Date: December 20, 2002

## OFFICIAL NOTIFICATION OF DECISION

FILE: **Project # 1002329**  
02EPC-01682 EPC Site Development Plan-  
Amendment to Building Permit

St. Stephen's United Methodist Church  
4601 Juan Tabo Blvd. NE  
Albuq. NM 87111

**PHASE I NEW ADDITION SITE PLAN**  
SCALE: 1" = 30'

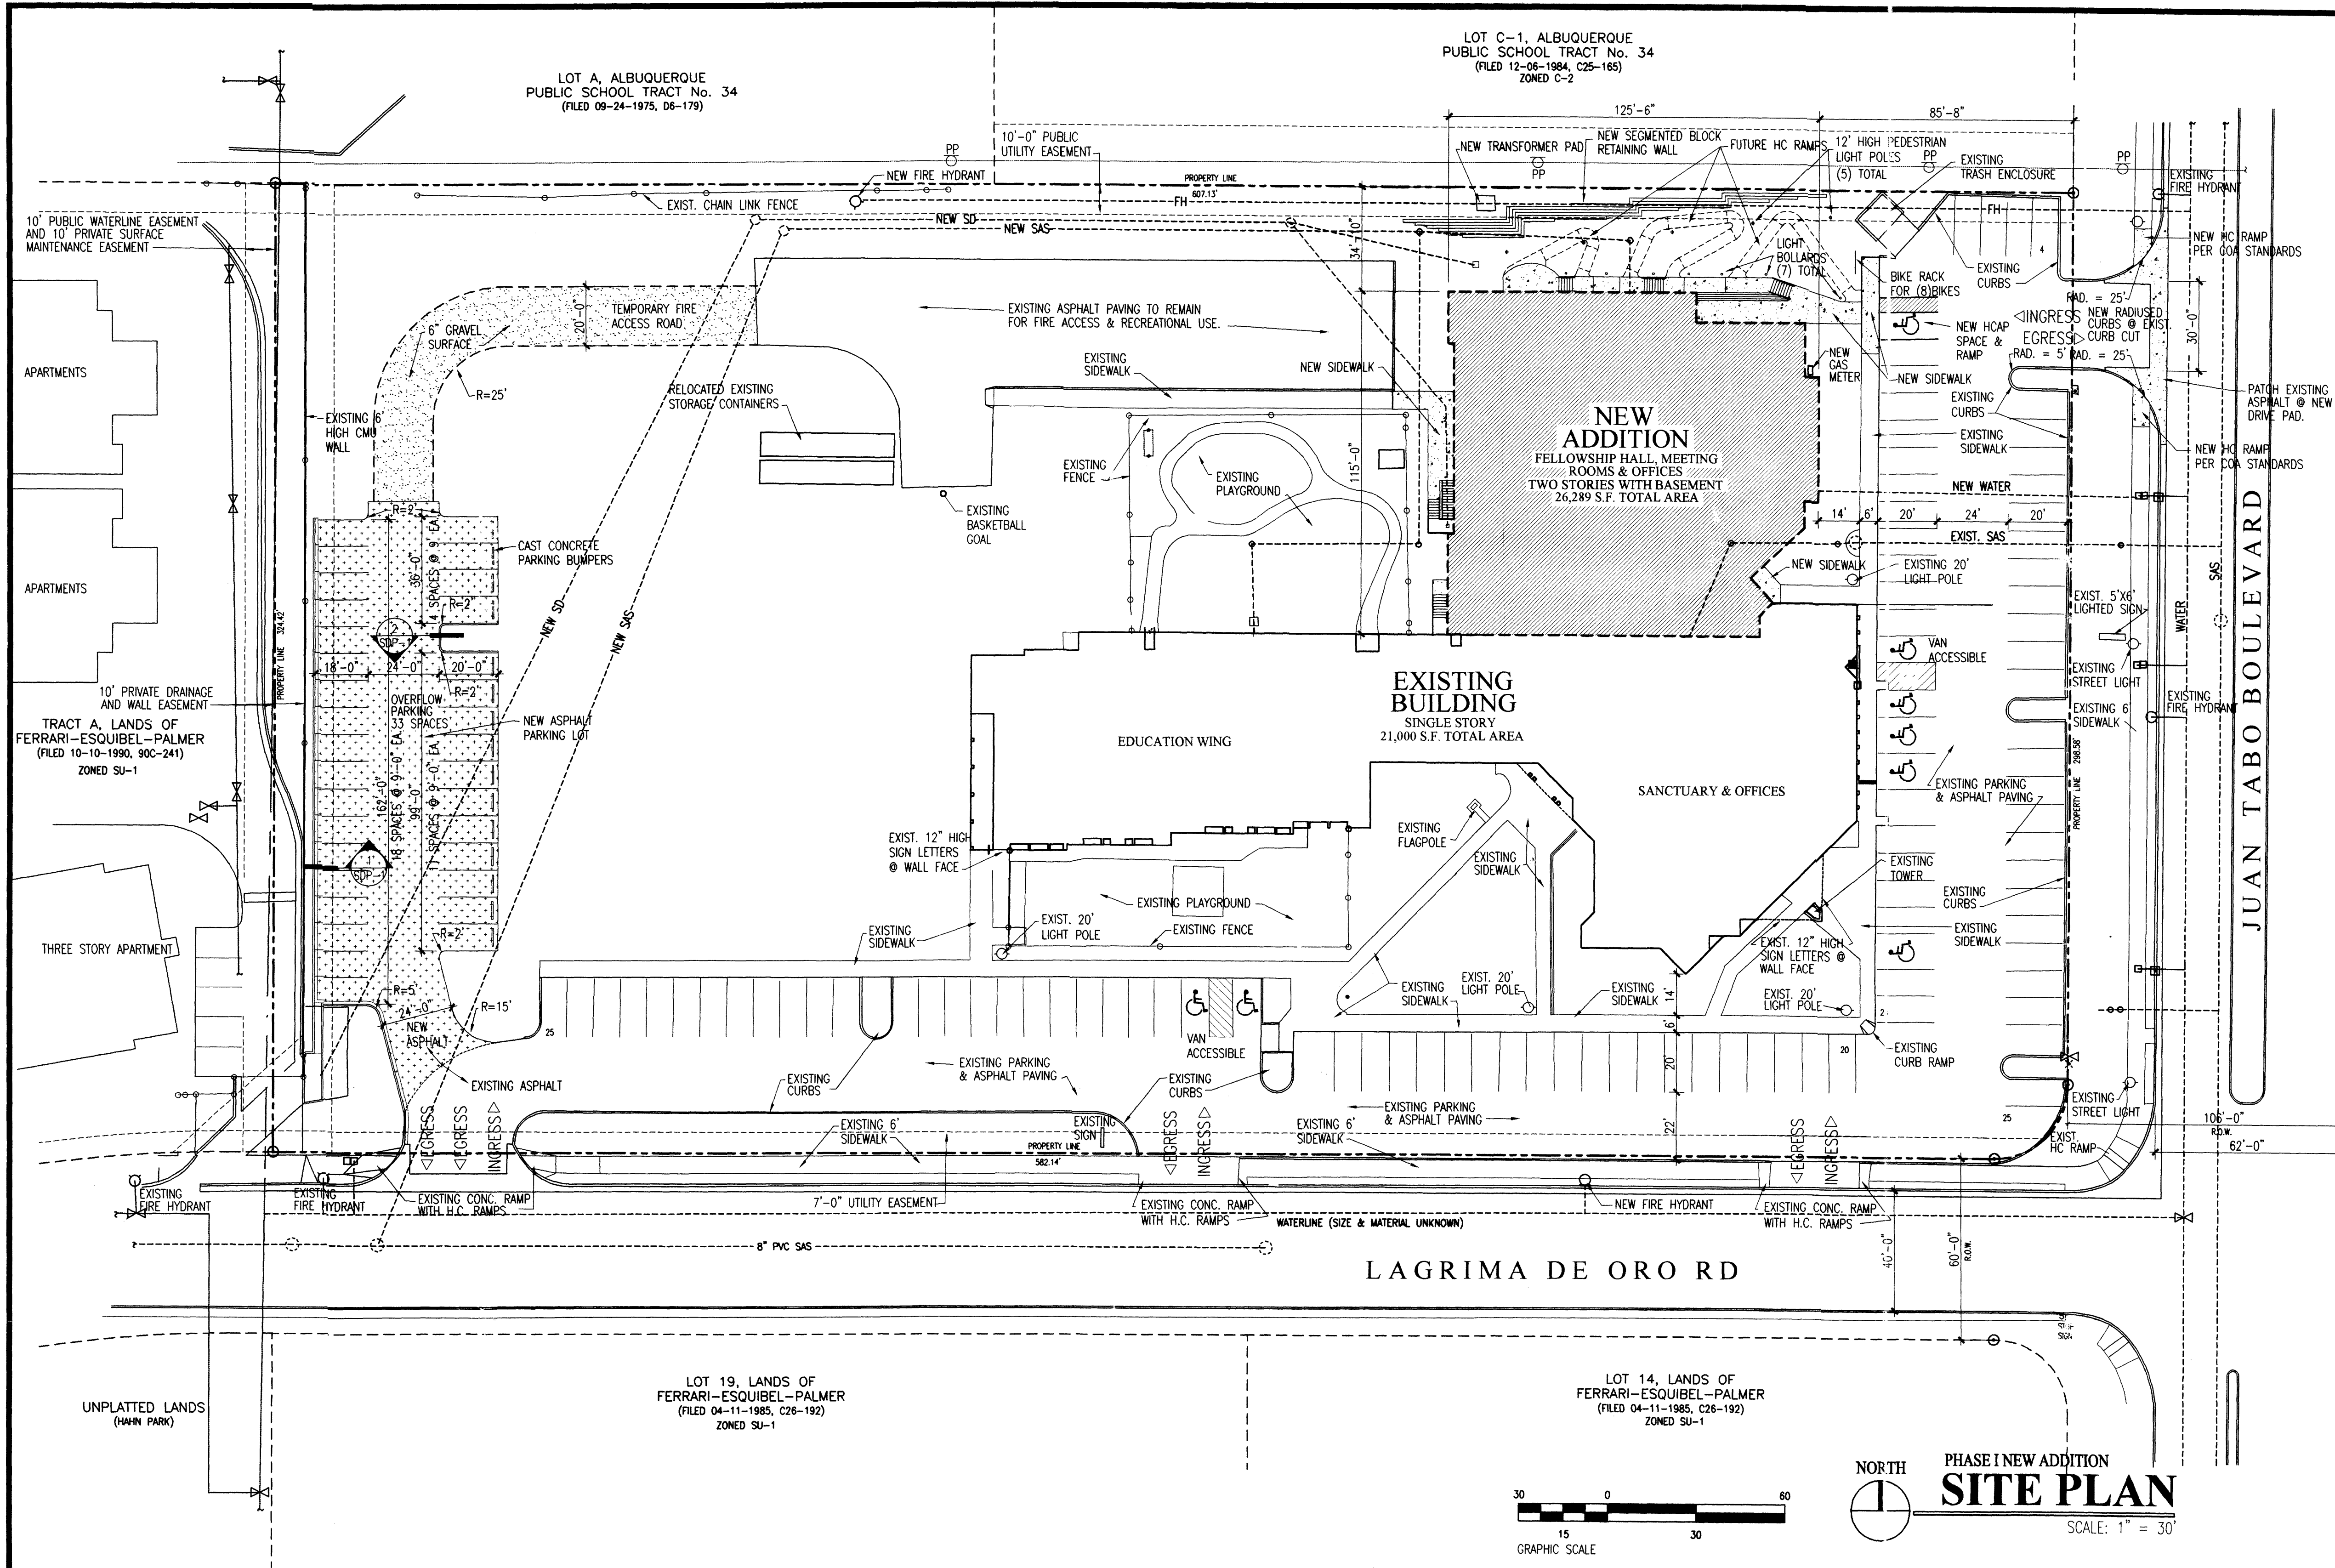
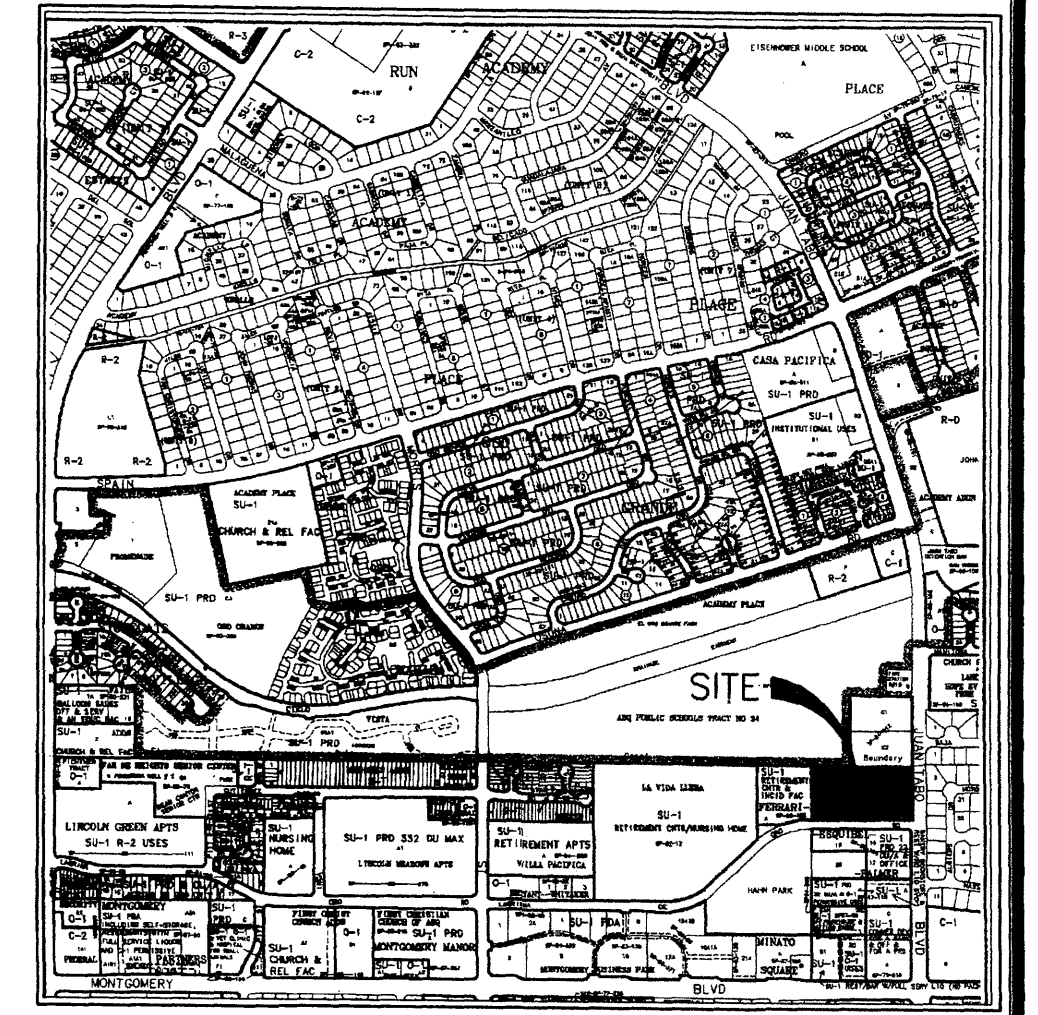
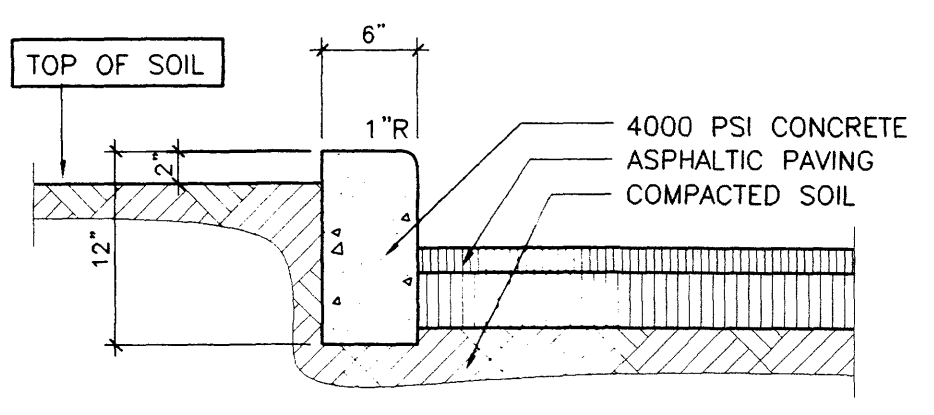
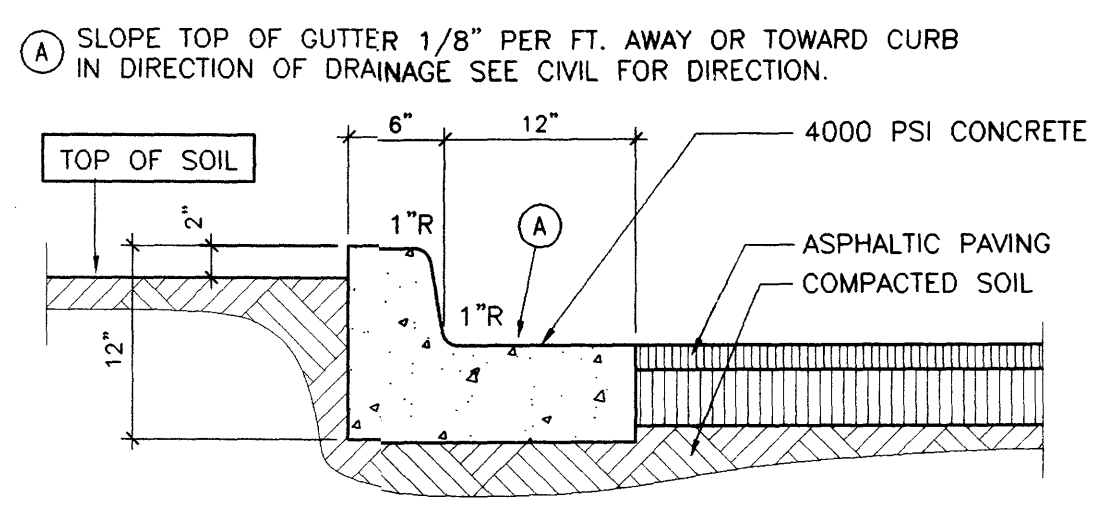
3. The applicant shall change the height of the proposed site lighting standards from 20 feet to 16 feet as the site is within 150 feet of a residential area, and provide illustrated locations of all site light fixtures as part of the DRB submittal of this request.

7. Required parking shall be provided on-site or on an adjacent site with a cross-parking agreement as part of the first phase of development. In the event that the Church pursues securing overflow parking arrangements on another parcel of land, the applicant shall provide a formal parking agreement for this parcel that specifies a coordinated and on-going availability of the needed 33 parking spaces in relation to completion of the proposed Church addition. This agreement must be indicated on the submitted amendment to the existing site development plan for building permit in writing and in a physical layout of the overflow parking area including vehicular ingress/egress, parking layout with all dimensions, and pedestrian access from the overflow parking area to the subject site. In the event that the applicant is not able to provide such an agreement to the City, the applicant shall be required to provide for the Church's parking requirements on the subject site. The design of either alternative shall be reflected in the final sign-off submittal to the DRB

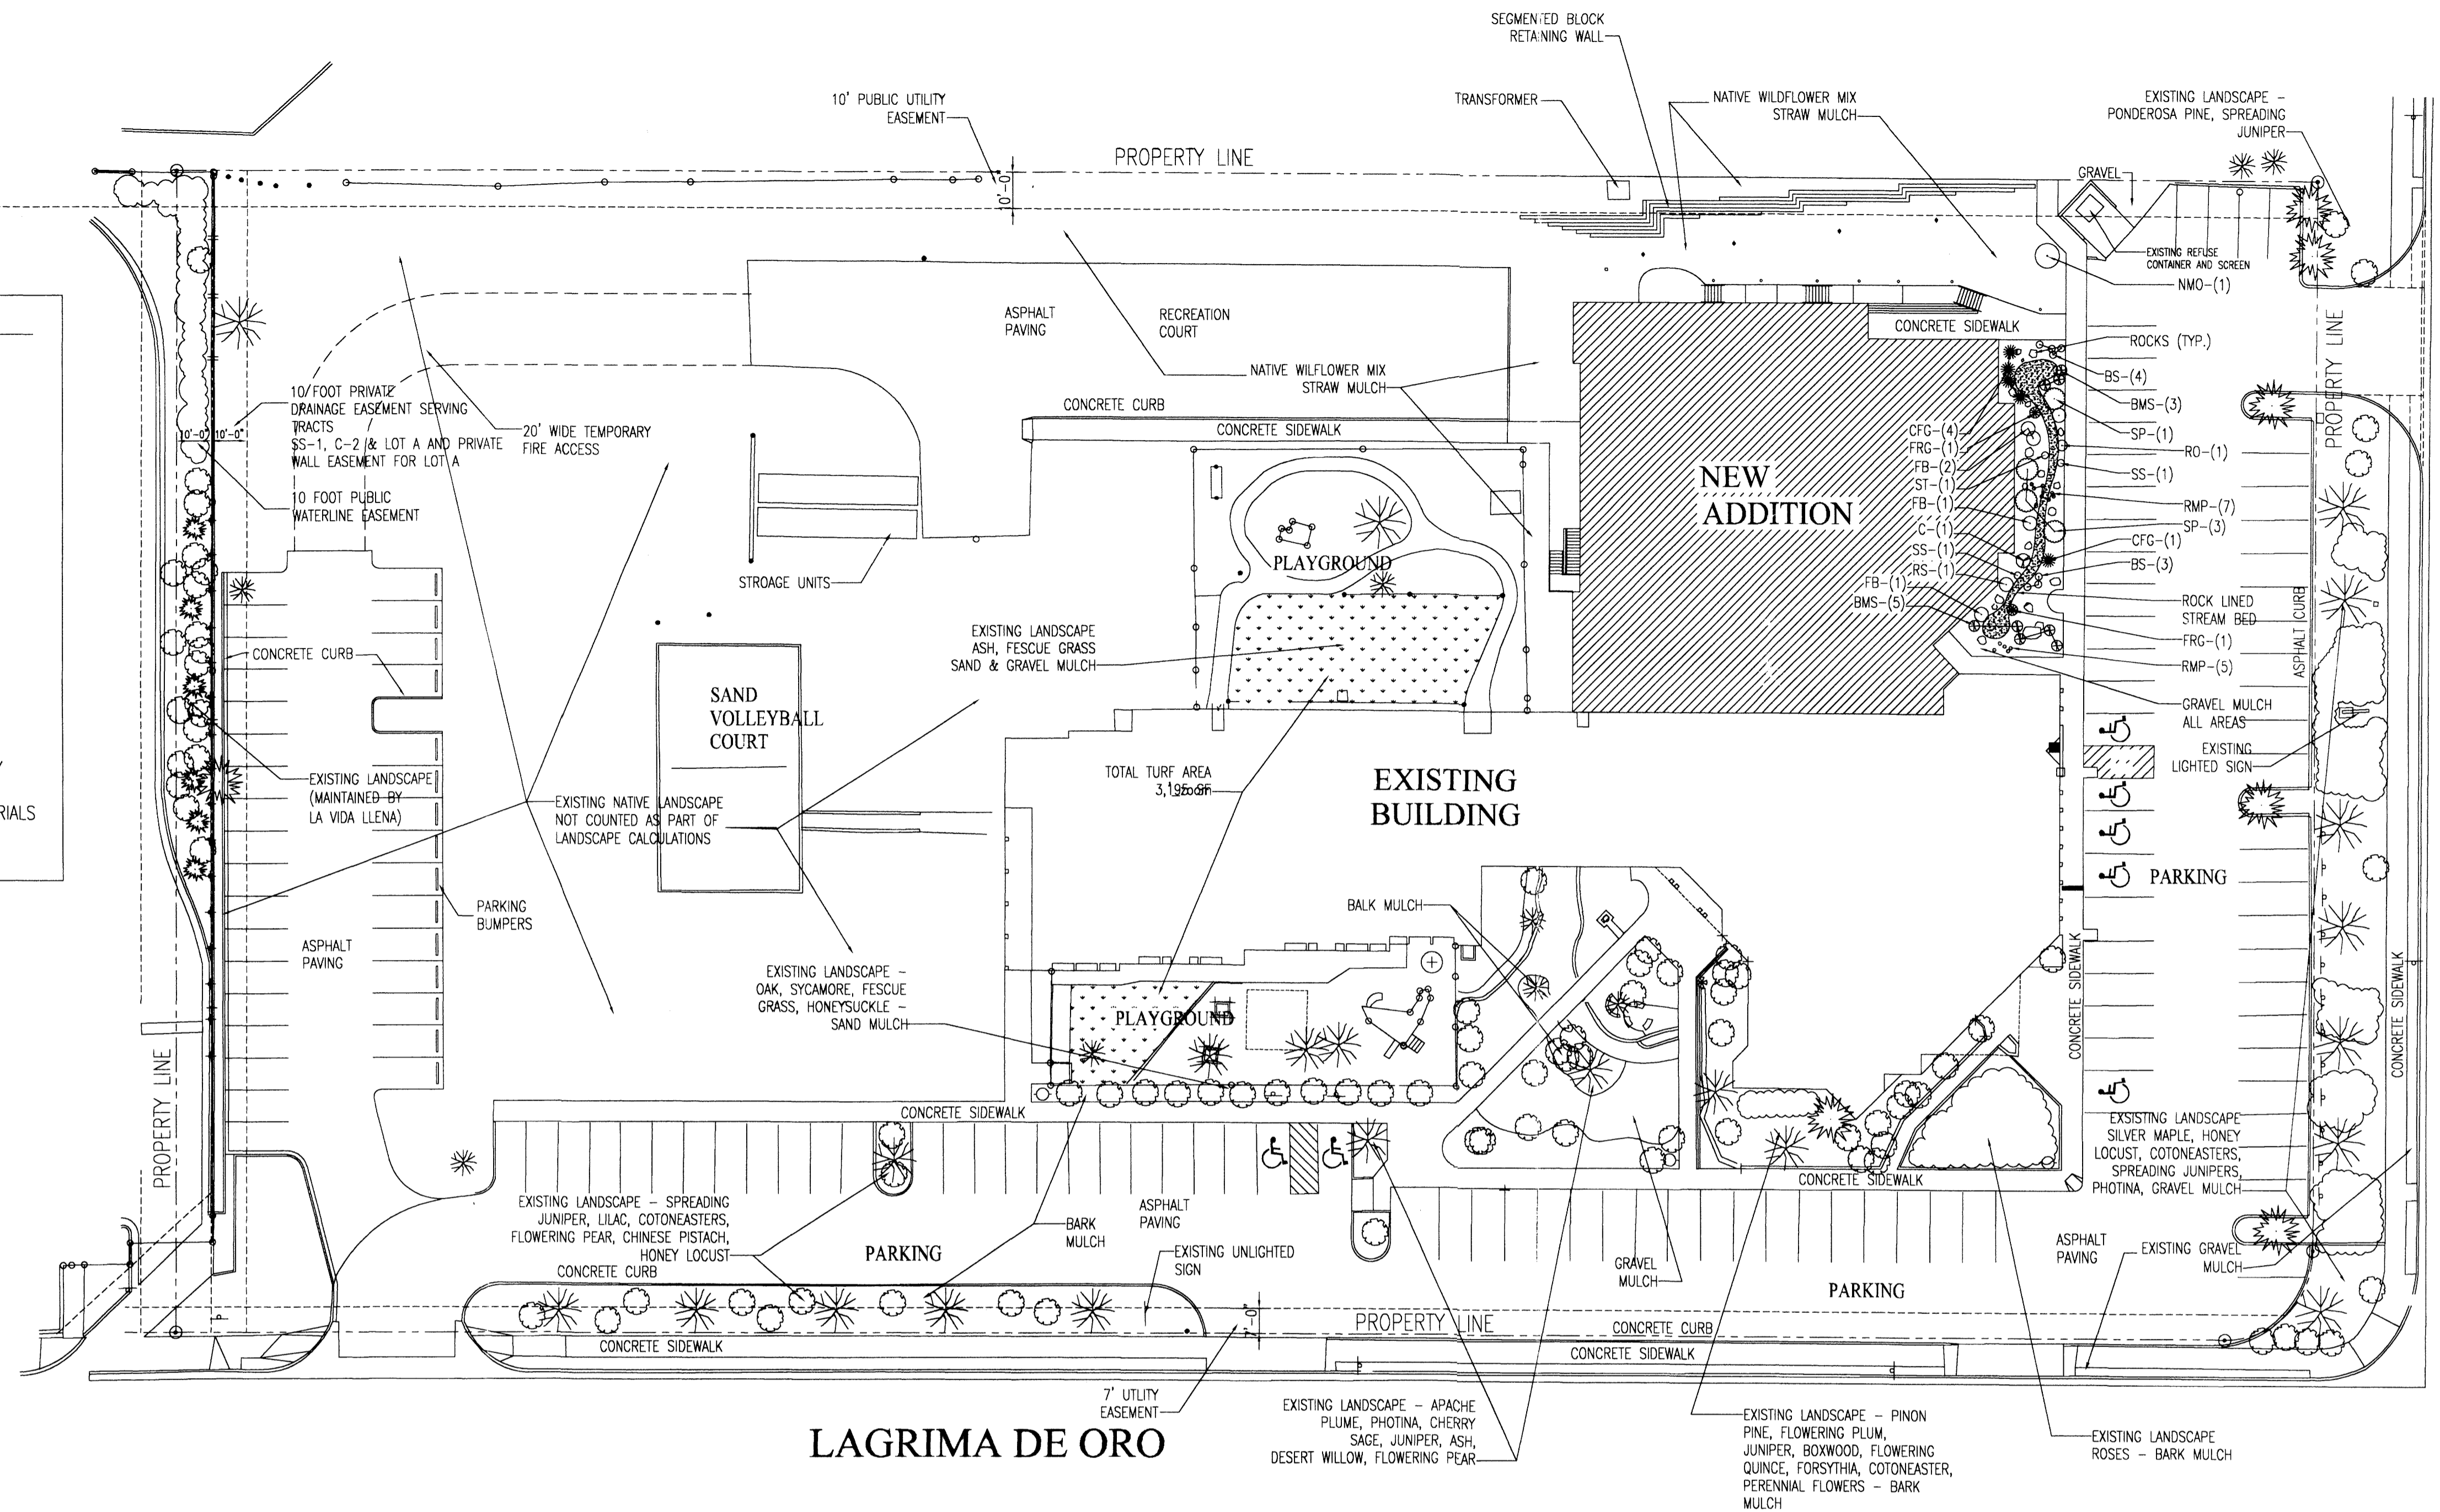
4. The applicant shall include a statement on the site plan that the landscaping shall provide 75% of groundcover by live and organic materials at full maturity for the entire site, as part of the DRB submittal of this case. And that all requirements of the Street Tree Ordinance be met.

**3 NORTH ELEVATION**  
 SCALE: 1/8"=1'-0"

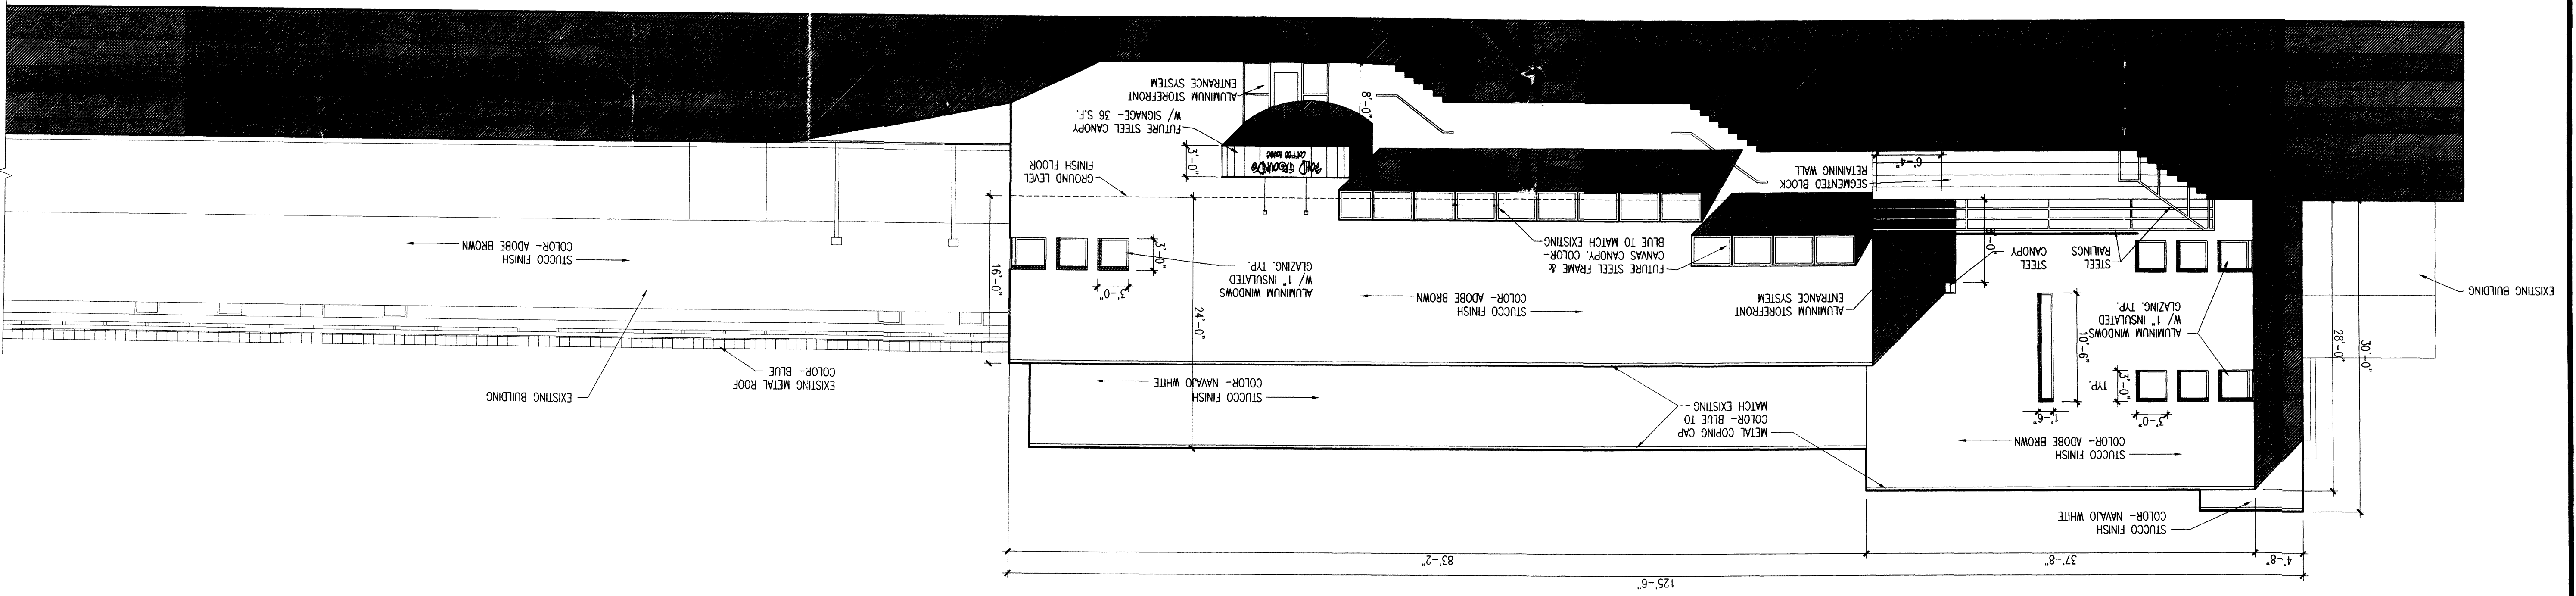
5. The applicant shall indicate colors for the doors and windows of the proposed building addition as part of the DRB submittal of this case.
6. The applicant shall clarify whether the proposed coffee house, as indicated by signage on the north elevation of the site plan, is an incidental facility related to the church use or a commercial business.
